Application No: FP/86/21/PL
Site Address: 7 Ambleside Close Felpham PO22 8NG
Description of Works: Erection of 1 No. 3 bed dwelling (resubmission following FP/179/20/PL).
This site is in CIL Zone 4 & is CIL Liable as new dwelling.

PROPOSED ELEVATIONS

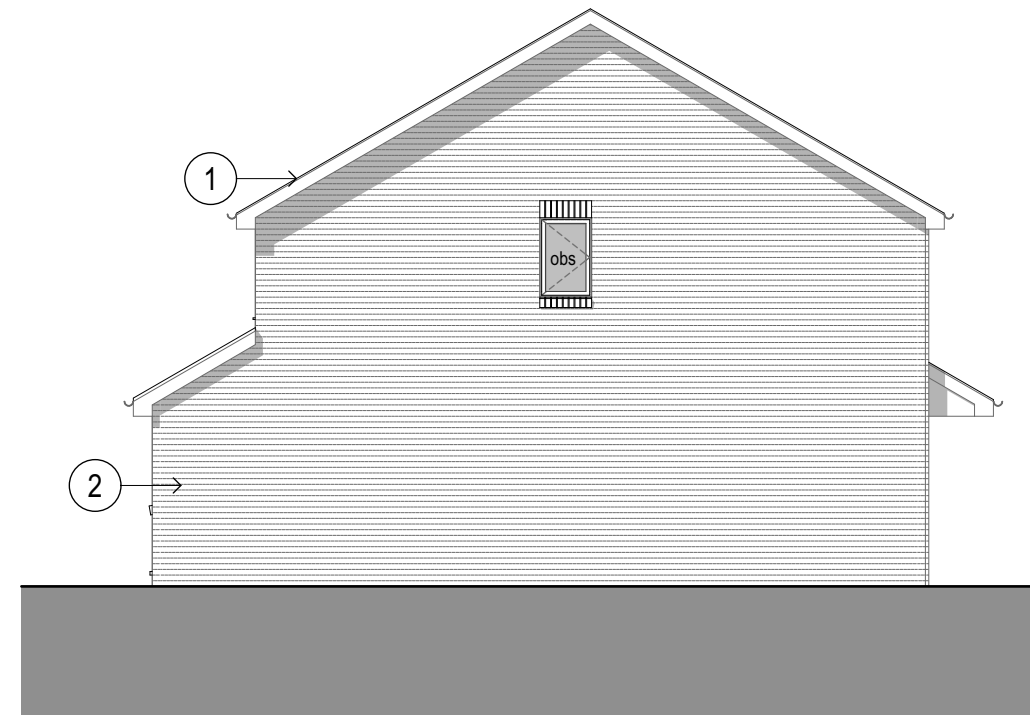
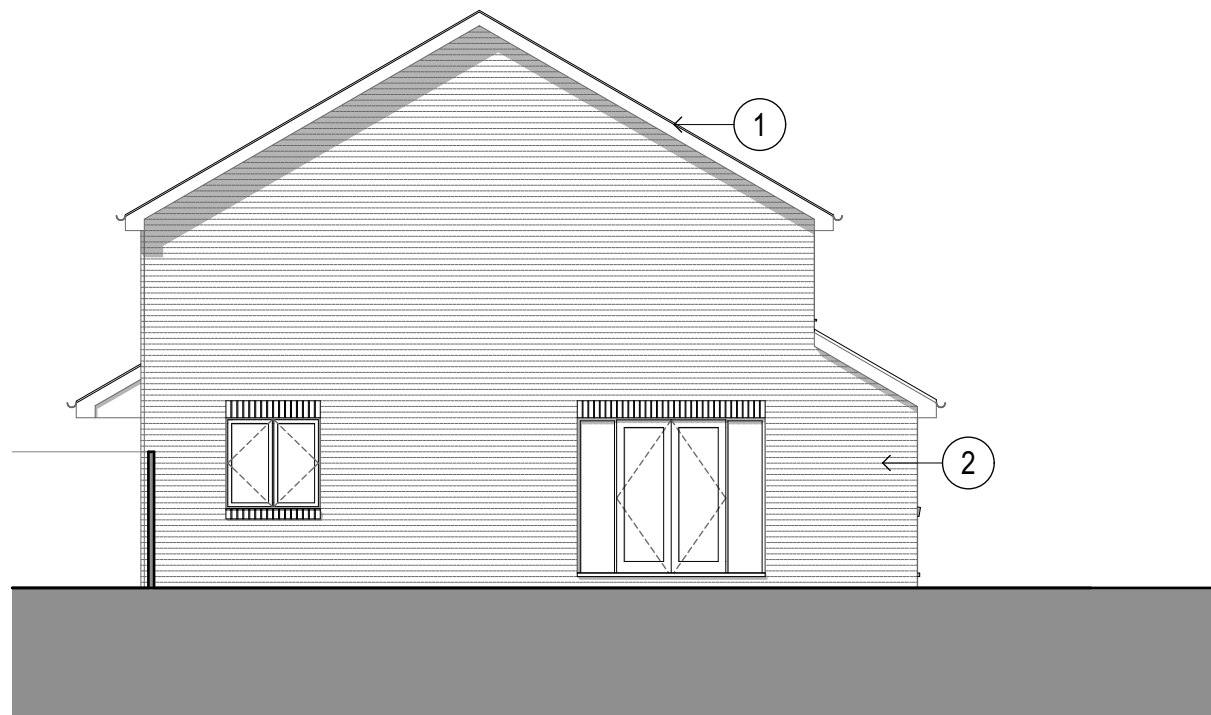
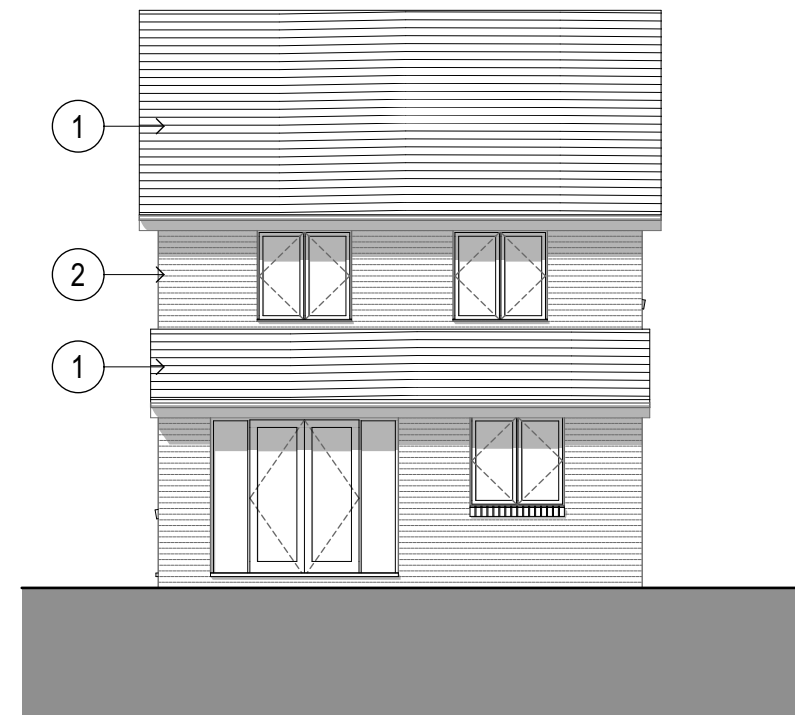
We require that a bat brick is integrated into the building onsite facing south/south westerly positioned 3-5m above ground.

We would like a bird box to be installed on the extension / and or tree within the garden of the property.
